An
Bord
Pleanála

Inspector's Report ABP-320327-24

Whether or not: (a) Structure No. 1: Gate Lodge A and Gate Lodge B; (b) Structure No. 2: semi-detached agricultural storage facility; (c) Structure No. 3: detached agricultural maintenance/storage facility; (d) Structure No. 4: electricity distribution building; (e) Structure No. 5: open fronted agricultural storage shed; (f) Structure No. 6: former agricultural building, now used to accommodate protected persons; (g) Structure No. 7 and Structure No. 8: pavillion and kitchen building; (h) Structure No. 10: former Belfry Building; (i) Structure No. 11: concrete paved area adjacent to structure no. 10 and 12; (j) Structure No. 12: accommodation block no. 1; (k) Structure No. 13: Art O'Neills building; (l) Structure No. 14: car park adjacent to the former Belfry Building; (m) Structure No. 15: large gravelled area to the north east of the holiday village; (n) Structure No. 16: accommodation block no. 2 and (o)

Kippure Lodge and Holiday Village,
Kippure Estate, Manor Kilbride,
Blessington, County Wicklow.

3 02 Rear Elevation
1 : 100

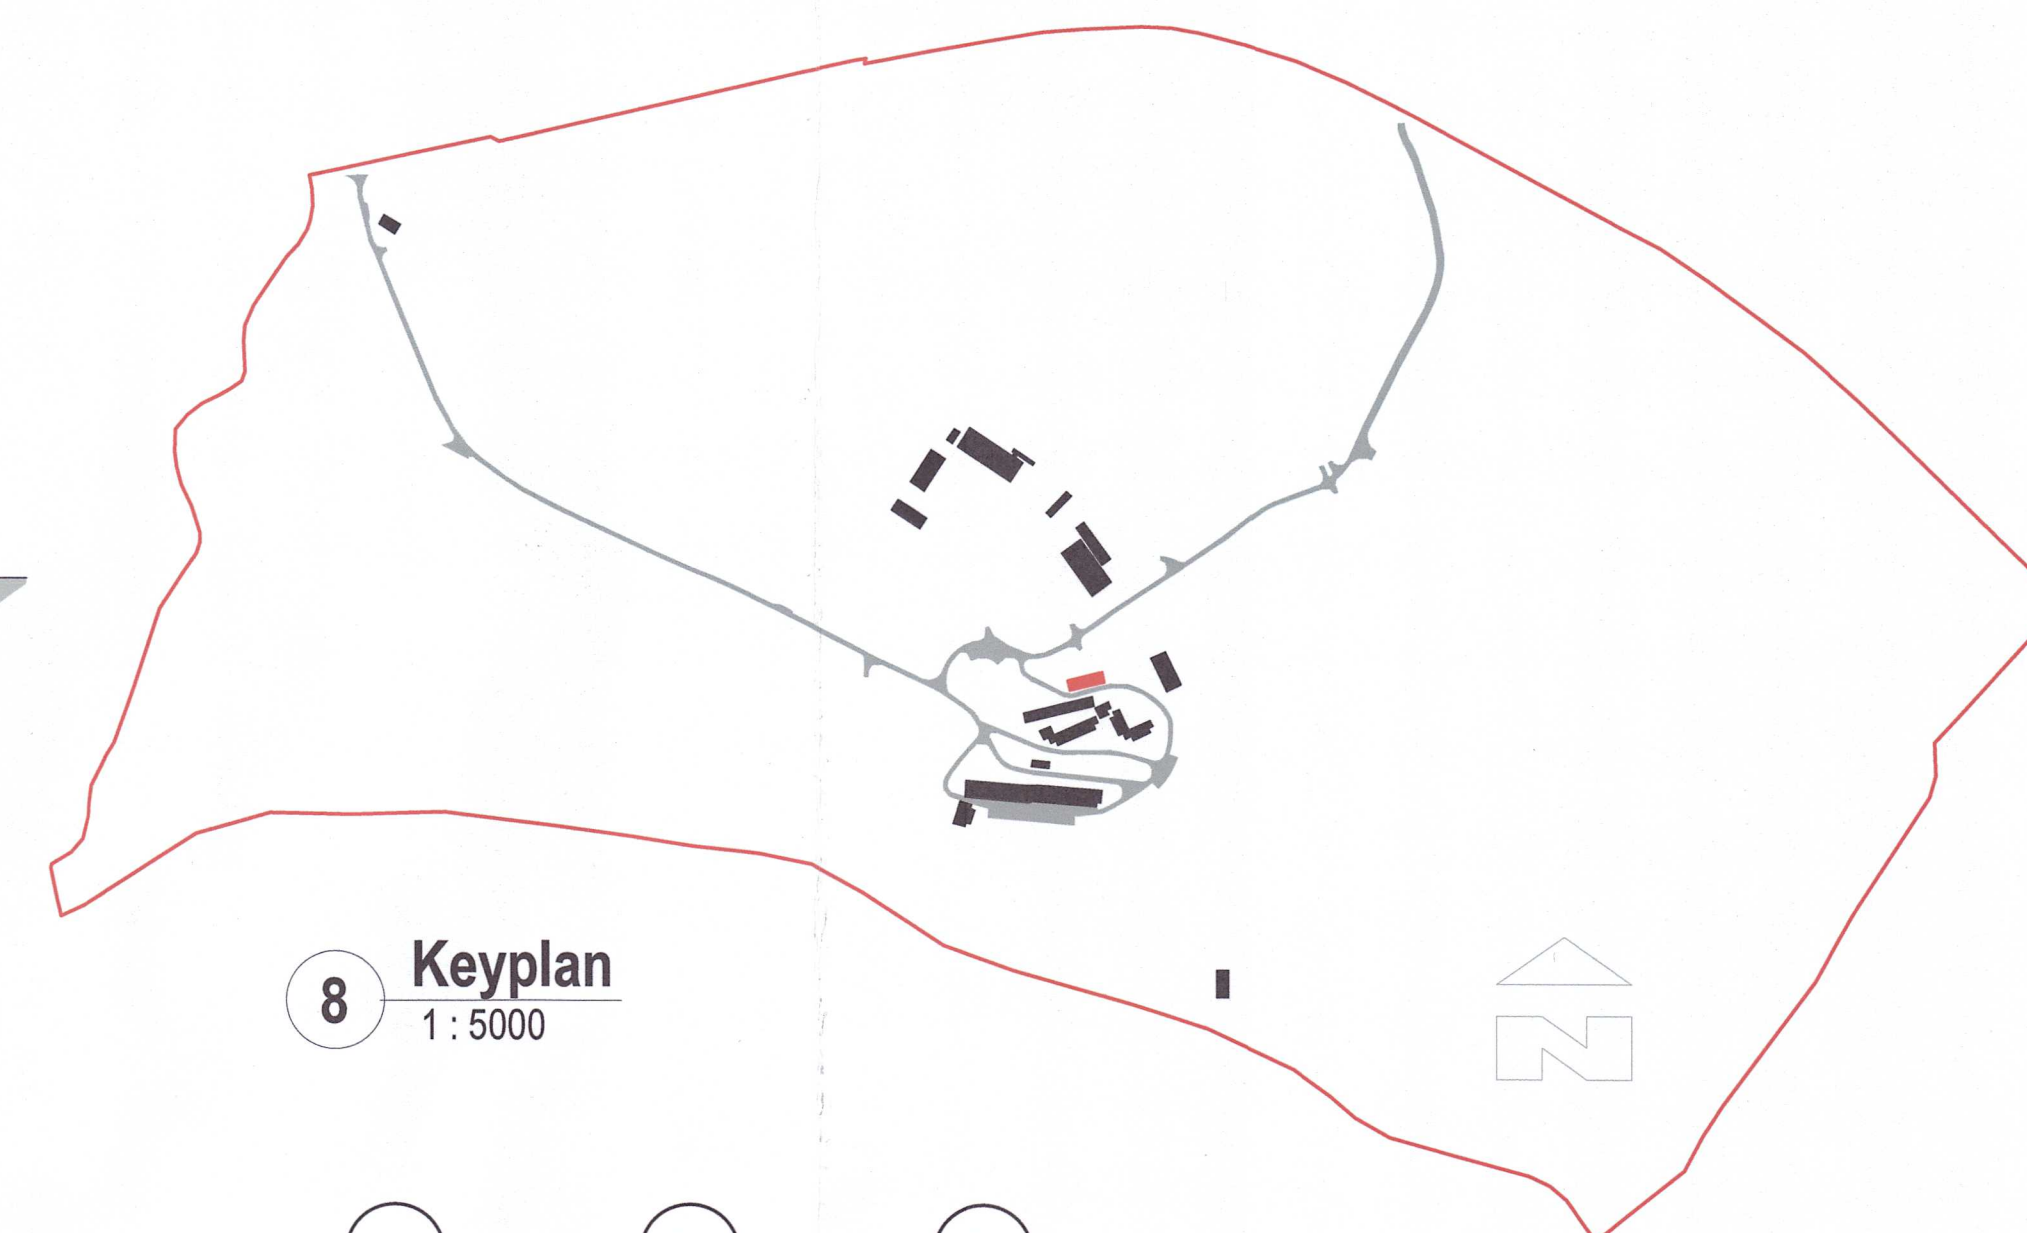
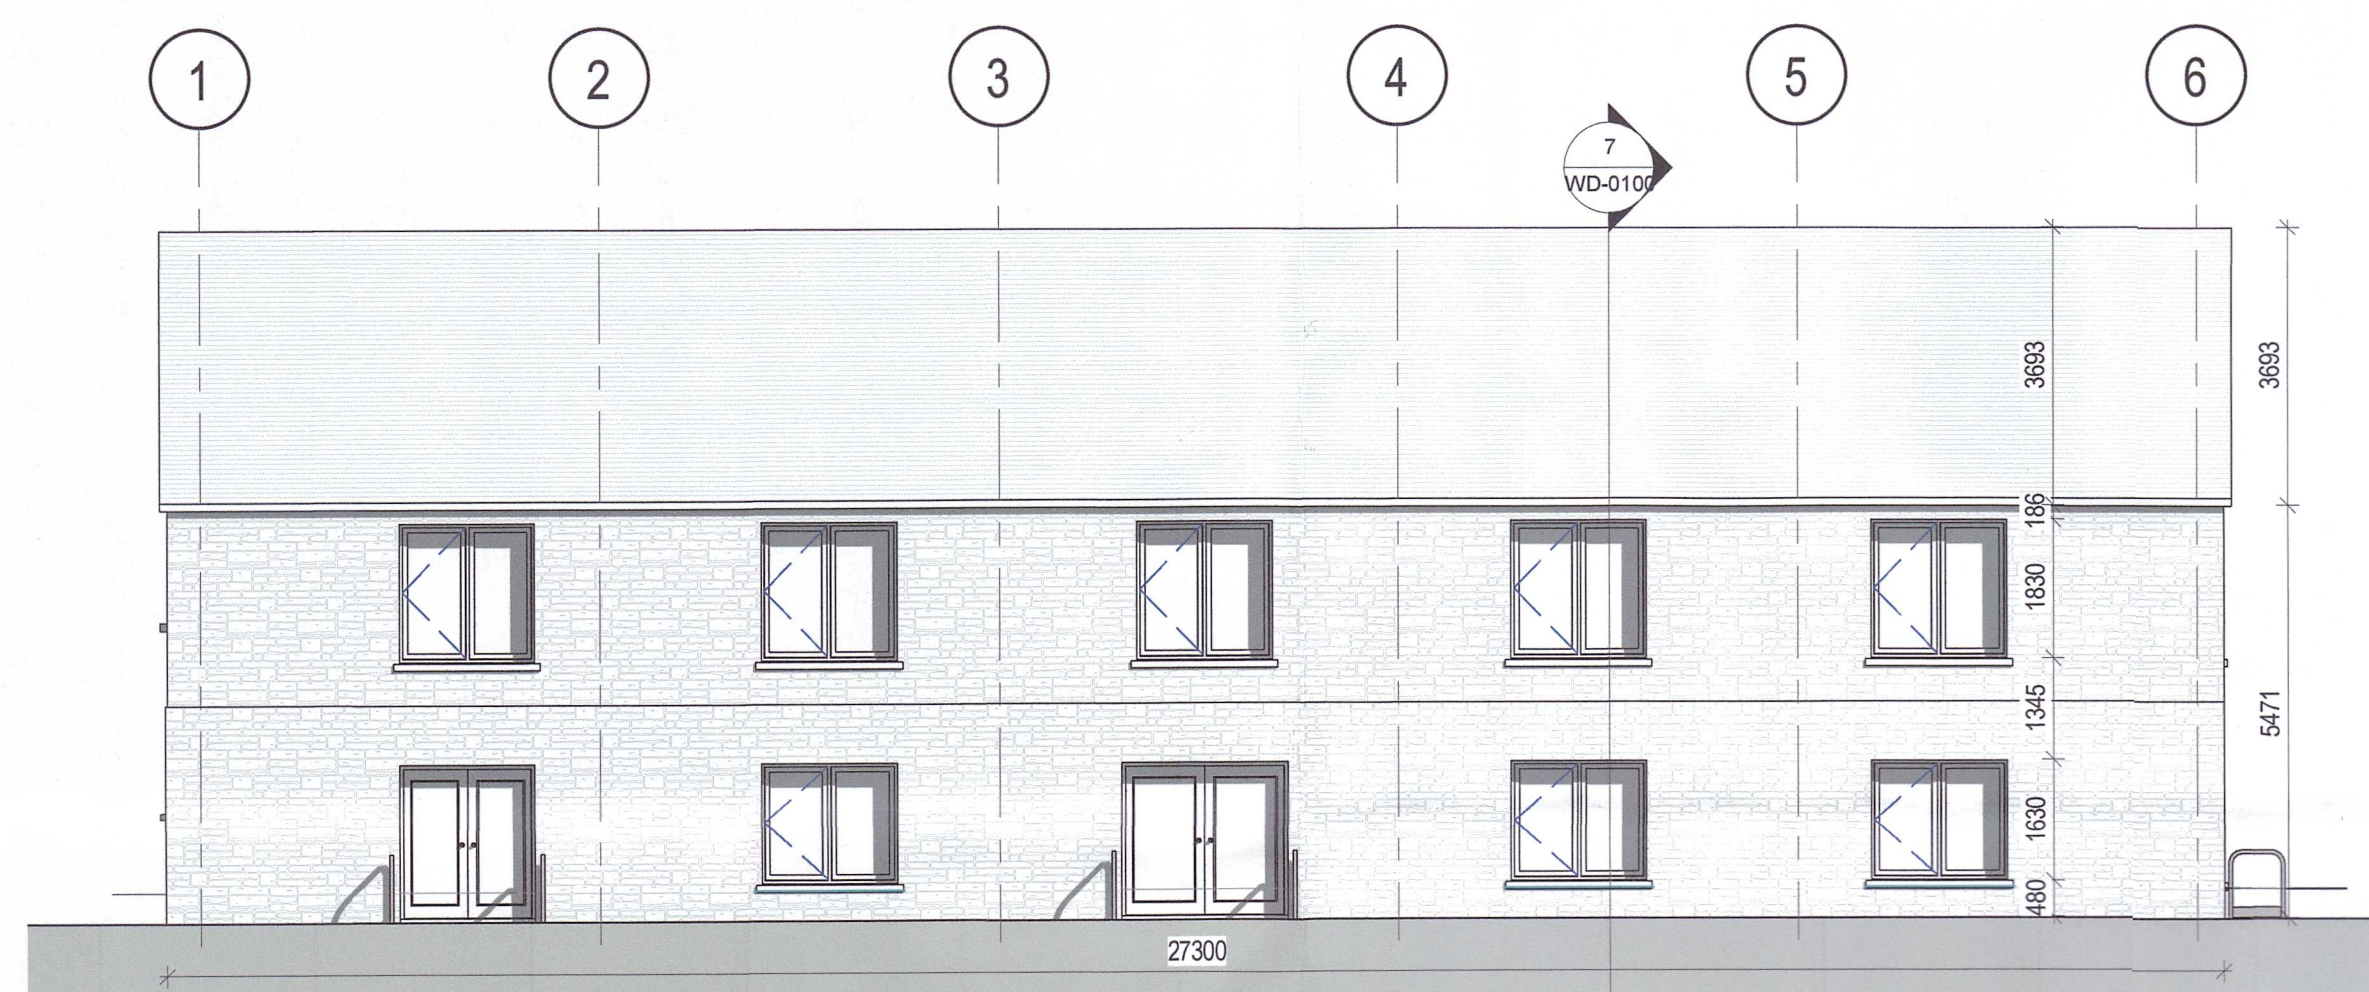
This building was constructed in c. 1830 and predates the Planning Acts and modern planning law. The structure has been upgraded and renovated as exempted development under Section 4(1)(h) of the PDA. Permission was also granted under Reg. Ref.05/2792 for the refurbishment of the Belfry Building and its use as a backup facility for outdoor facilities.

The structure has been extended and altered by reference to changes in height, length and width. The nature of the works would not comprise maintenance, improvement or other alteration and result in the structure being materially different to the former structure. The works have significantly altered the external appearance of the structure so that it is inconsistent with the character of the structure.

There are no other exemptions available for this structure. Therefore, it is development and is not exempted development.

Structure 12

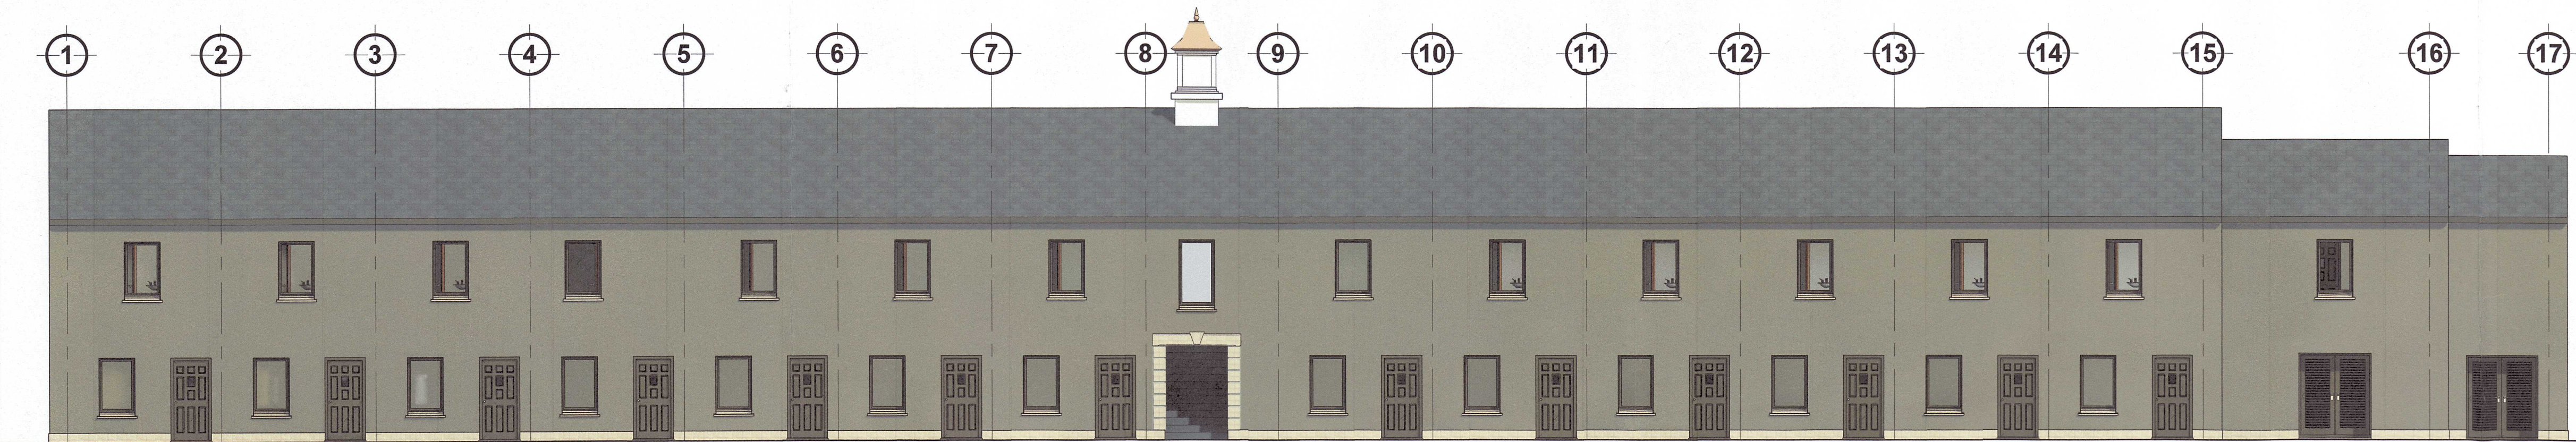
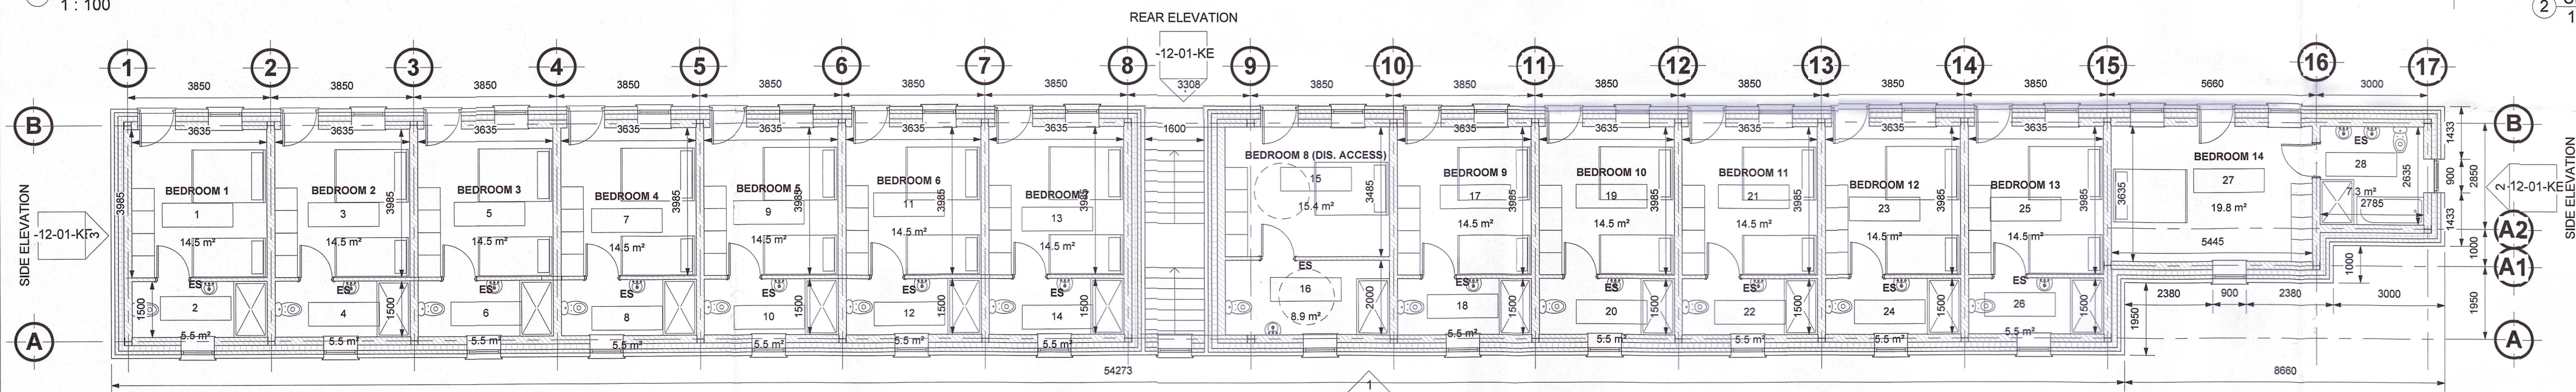
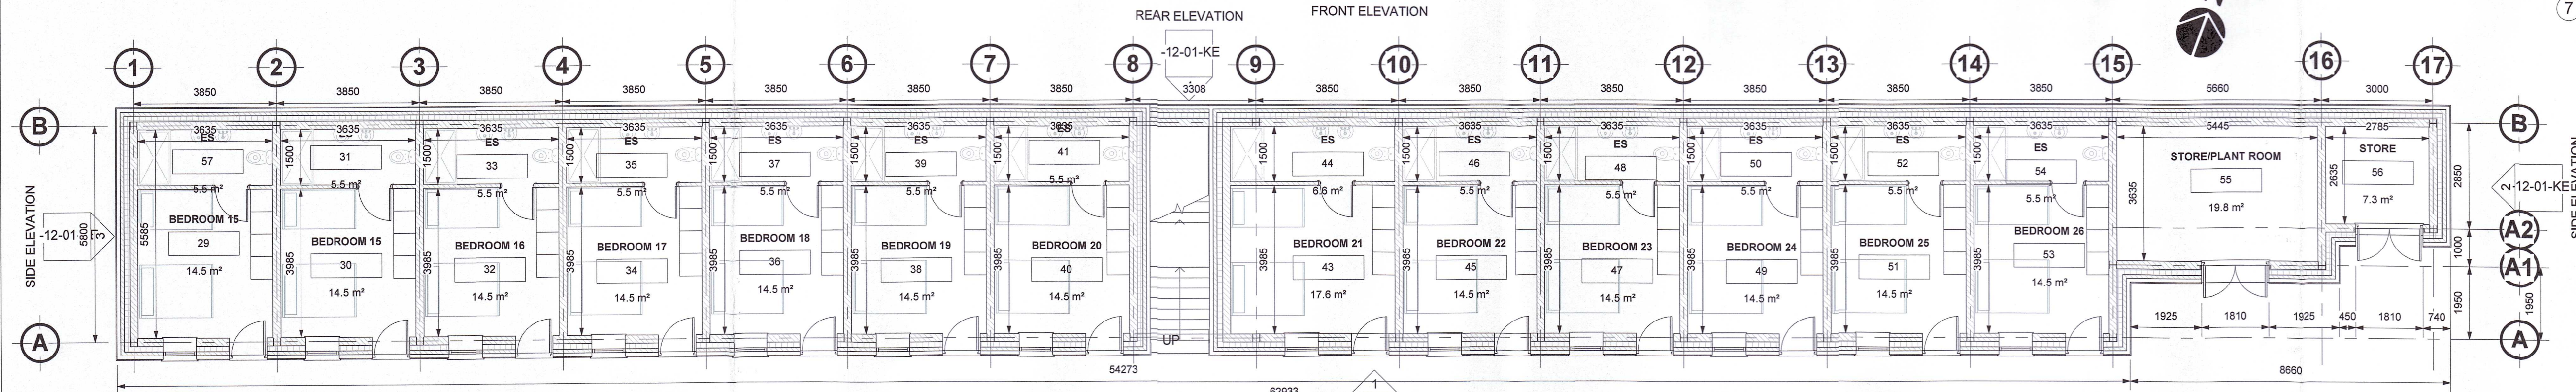
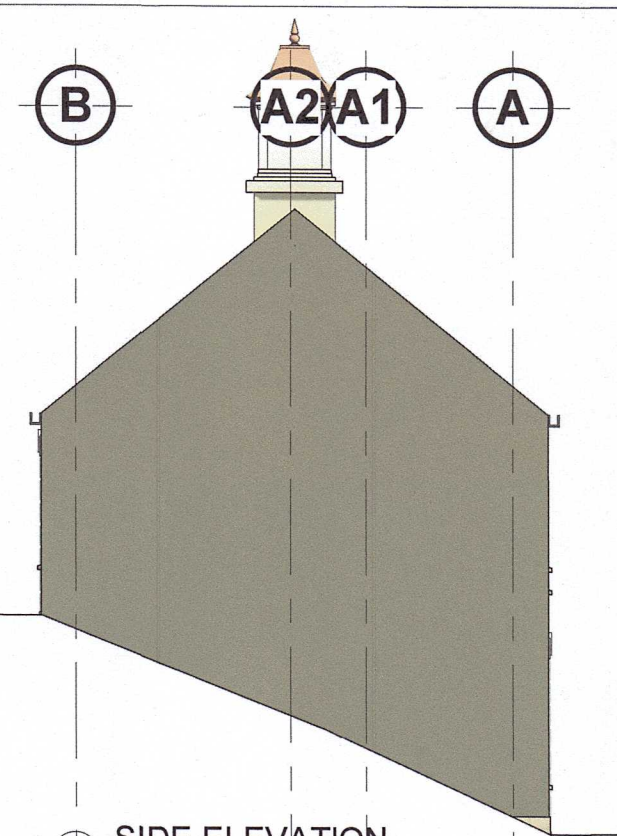
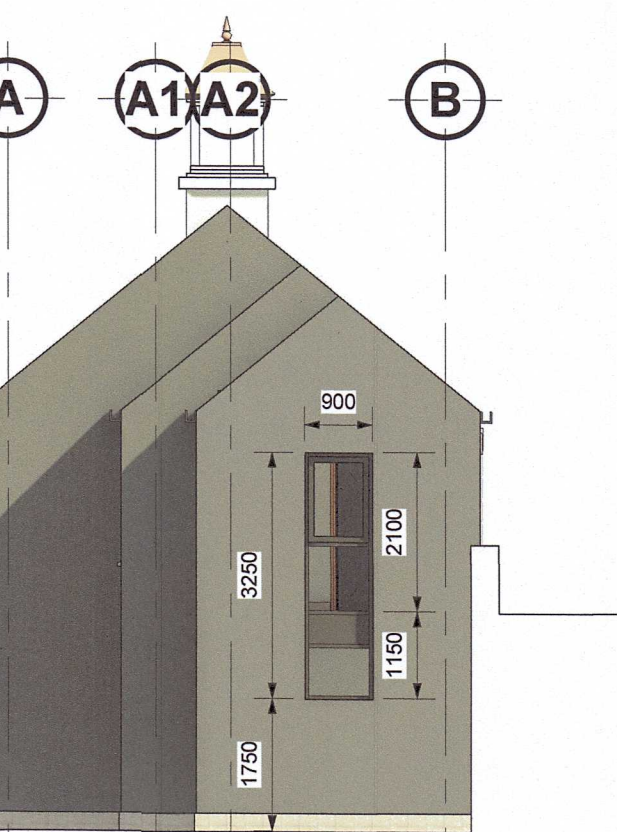
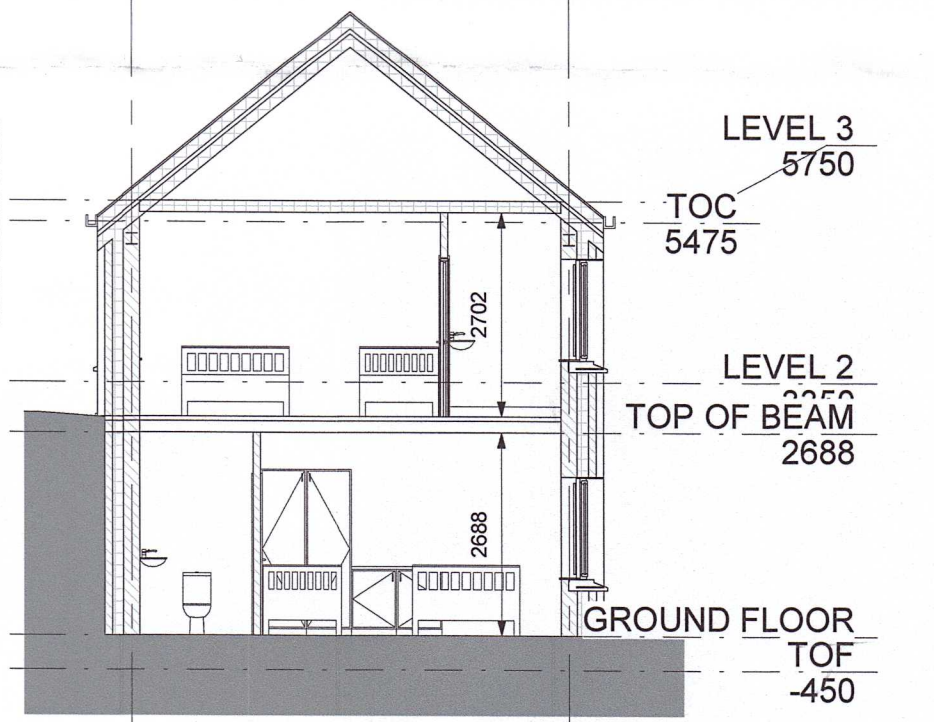
It would appear from drawings submitted with Reg. Ref. 99/1150, aerial photography and photographs from 2011 / 2012 that the Long Barn is not Structure 12. In addition, aerial photography from 2020 shows there are no structures within the location to the north of the holiday homes, the retained structure (Reg. Ref. 99/1150) and Structure No. 10: The Belfry. Therefore, it is considered that Structure No. 12 is a newly constructed accommodation unit.

Section 4(1)(h) is not applicable as this is a new structure.

This structure is development and is not exempted development.
